## The Planning Inspectorate Yr Arolygiaeth Gynllunio

### **Application by AQUIND Ltd for the AQUIND Interconnector**

#### **The Examining Authority's first written questions**

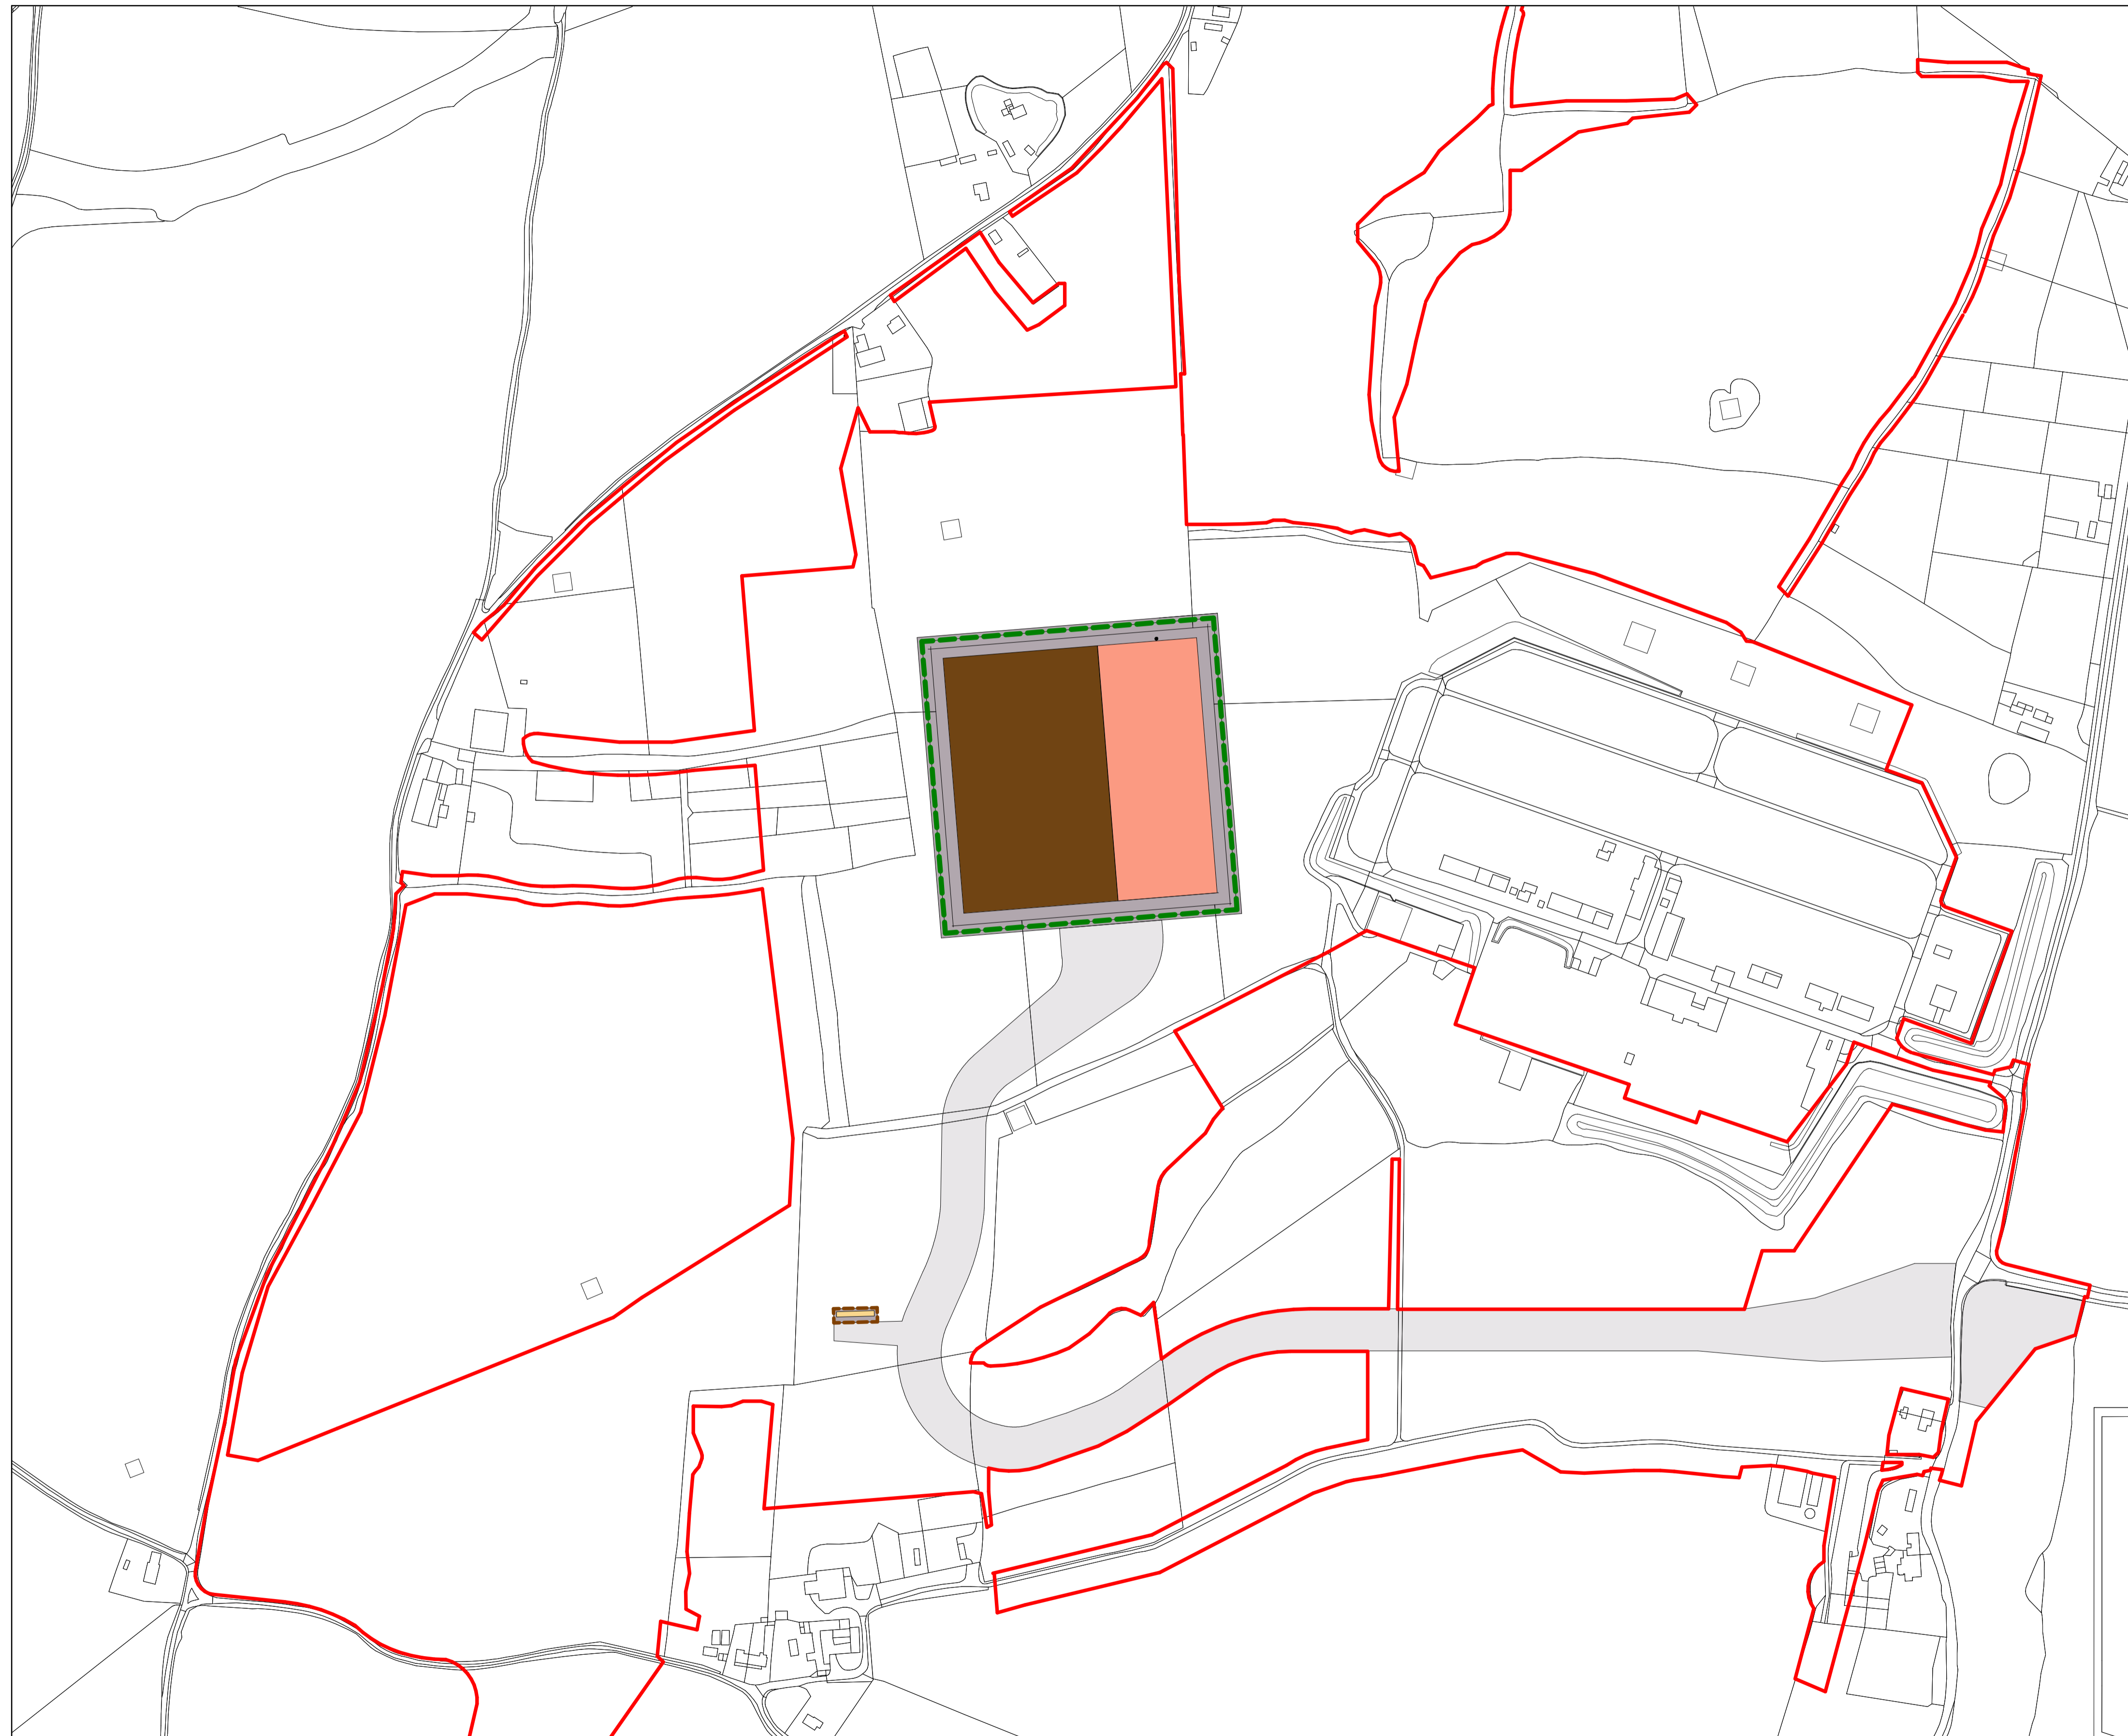
Reference	Respondent(s)	Question	Response By Winchester City Council
			attention focusing on the materials.
MG1.1.6	The Applicant	<p>Please describe how the final finished floor level for the Converter Station was arrived at, and how this is dealt with in the design principles and parameter plans and tables ([APP-012] and [APP-019]).</p> <p>Confirm that the EIA used the 'worst case' within the Rochdale envelope that is set for this, especially LVIA and in relation to impacts on groundwater.</p>	
MG1.1.7	The Applicant	<p>In the Onshore Outline CEMP [APP-505], there are numerous references to SINCS, but these do not seem to appear on the constraint maps in Appendix 1. Please can the Applicant clarify.</p>	
MG1.1.8	The Applicant	<p>In Table 2.1 of the Onshore Outline CEMP [APP-505], please could the Applicant explain why:</p> <ul style="list-style-type: none"> <li>• not all receptors addressed later in the document are included in this summary list (for example, hedgehogs and Wildlife and Countryside Act Schedule 9 plants);</li> <li>• '<i>semi-improved negligible and calcareous grassland</i>' appears twice in the onshore ecology entry: and please clarify what is meant here by 'negligible';</li> <li>• the list in the heritage and archaeology entry is restricted to below-ground archaeological assets and excludes built heritage assets.</li> </ul>
